**Your Ref:** OWPC19308  
**Our Ref:** R/134/18/PL 01-06-2018  
**Please ask for:**  
Mrs A Gardner

1 No. end of terrace two storey dwelling  
8 Duncton Road Rustington

Thank you for your internet representation made on 14th July 2018 which has been recorded as '**an objection**' with the comments as follows:

Drawing P01      May 2018      Scale 1:100 @ A3  
Planning Drawing - Site Plan & Floor Plans

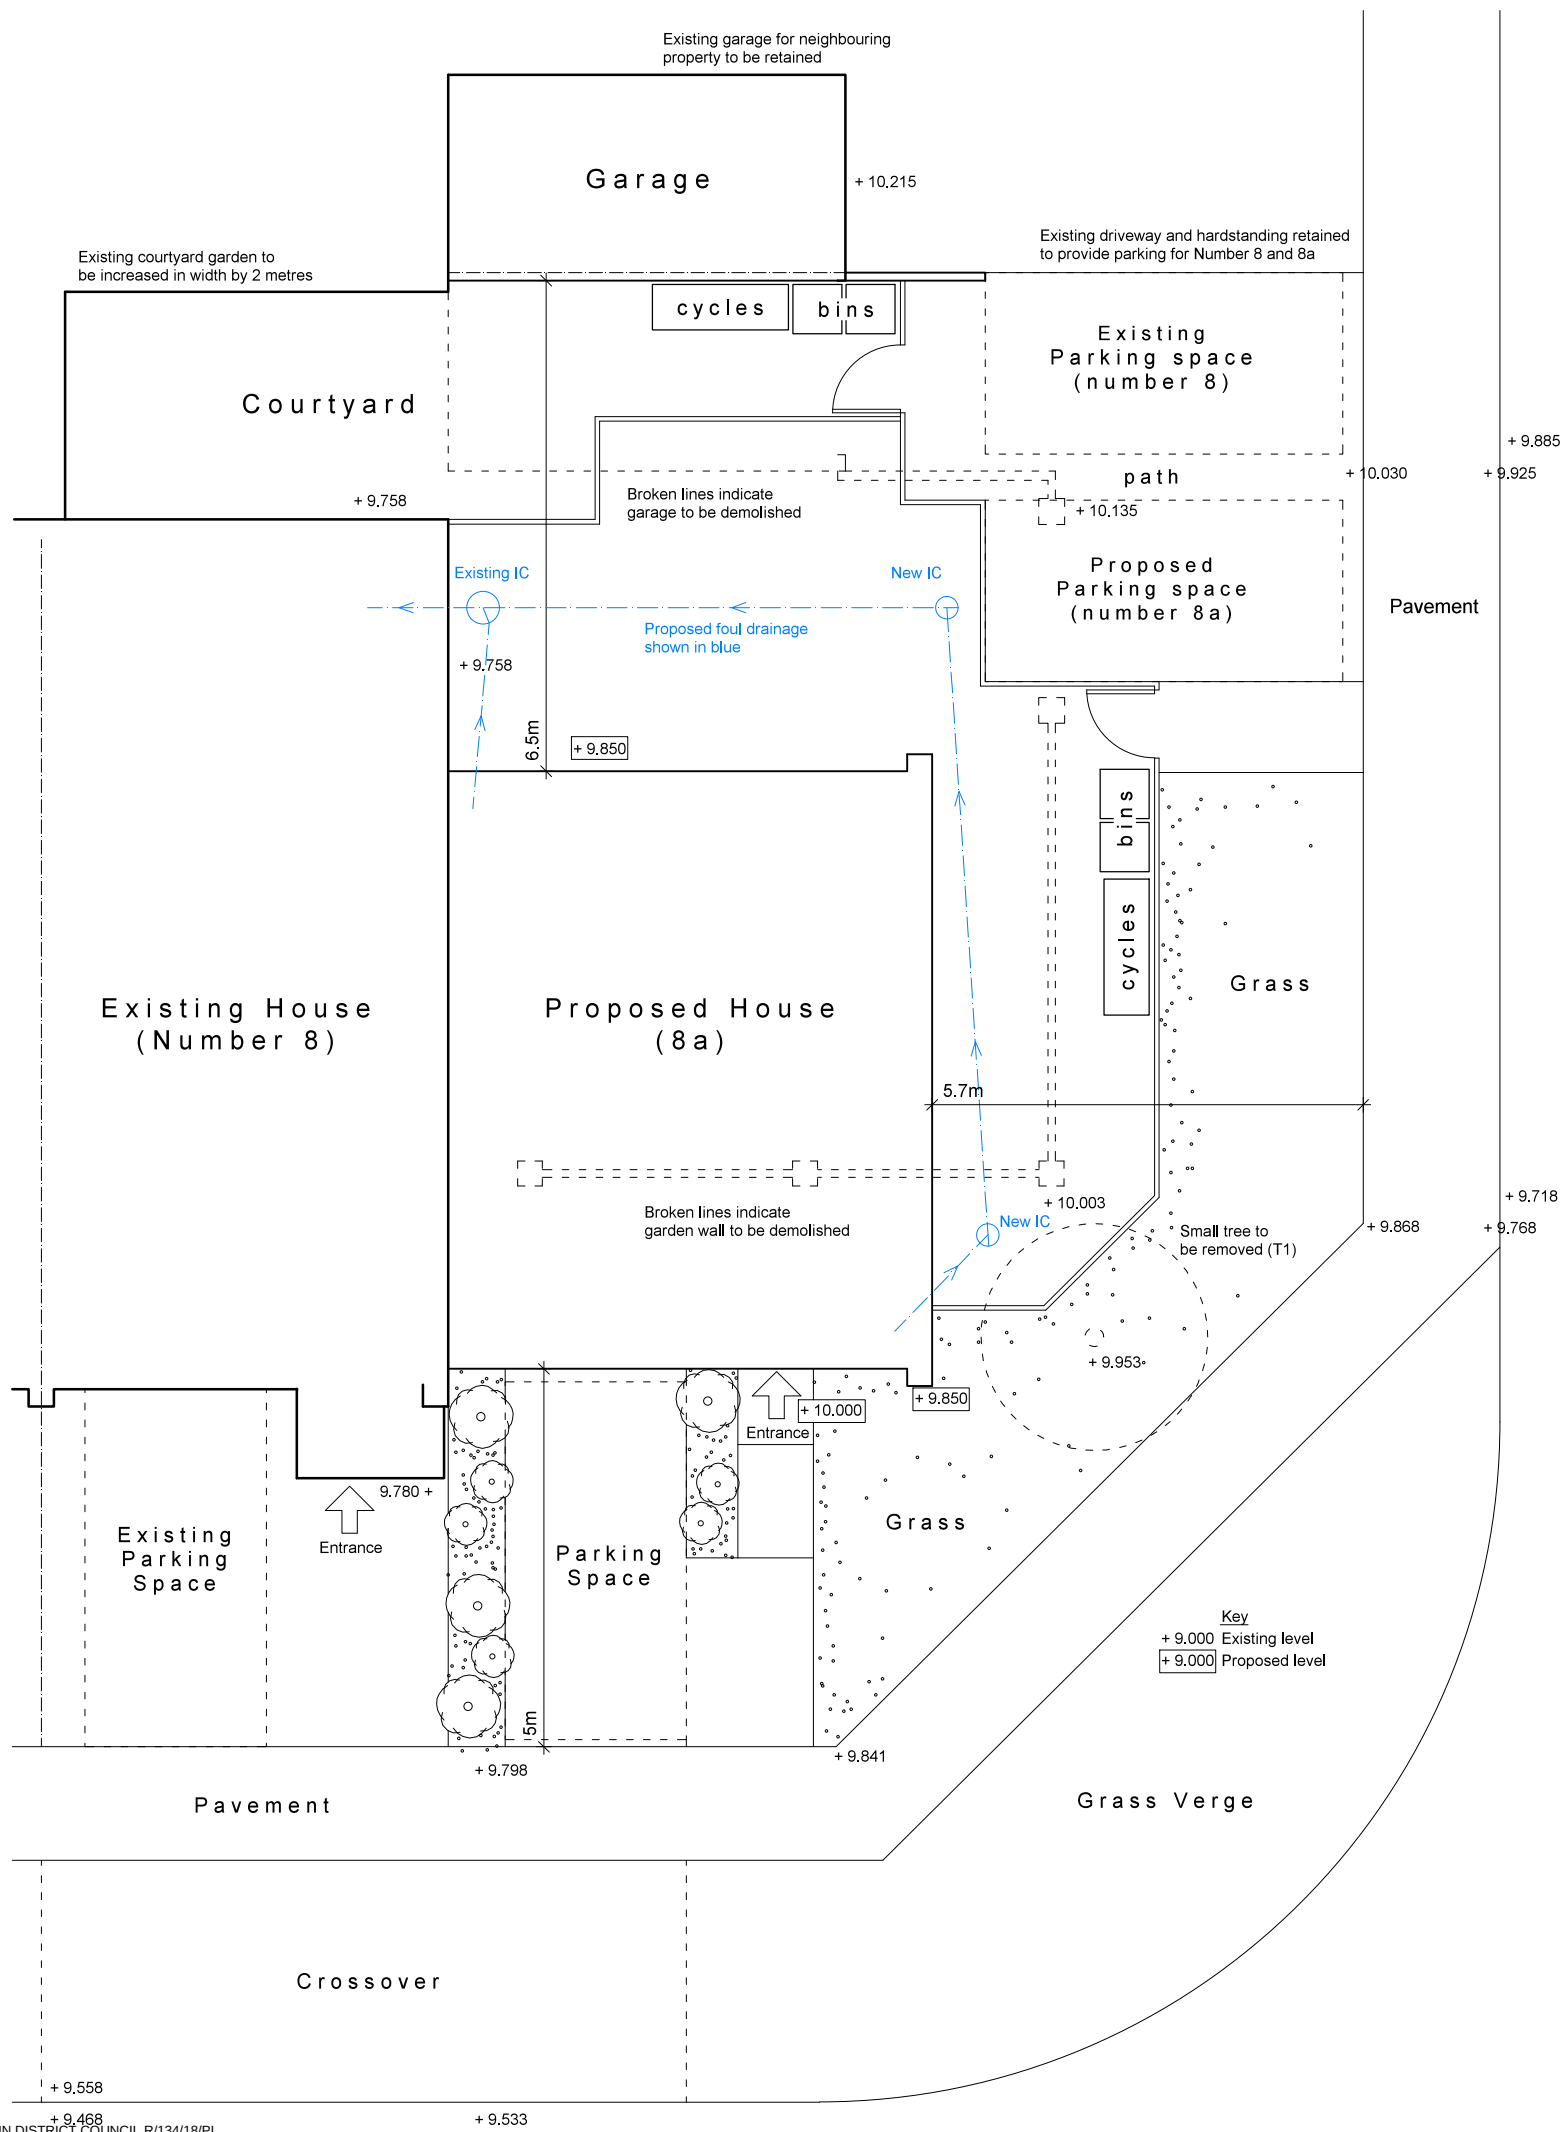
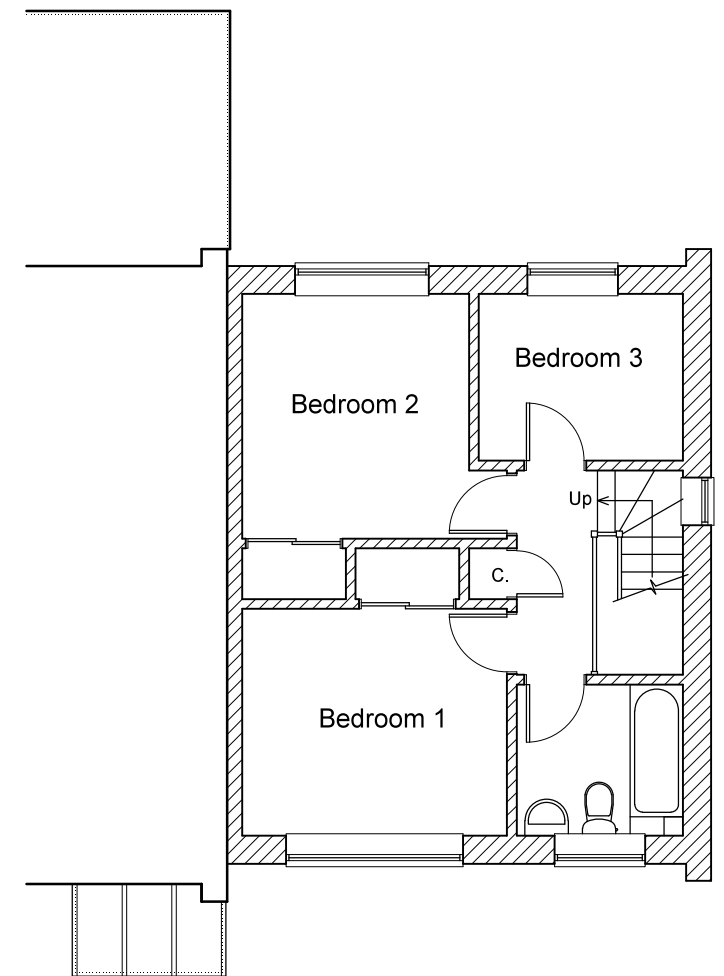
*I would also note that the plans submitted show an existing parking space in front of the current house, No 8. This is incorrect, there is no space there so I would suggest the plans are wrong.*
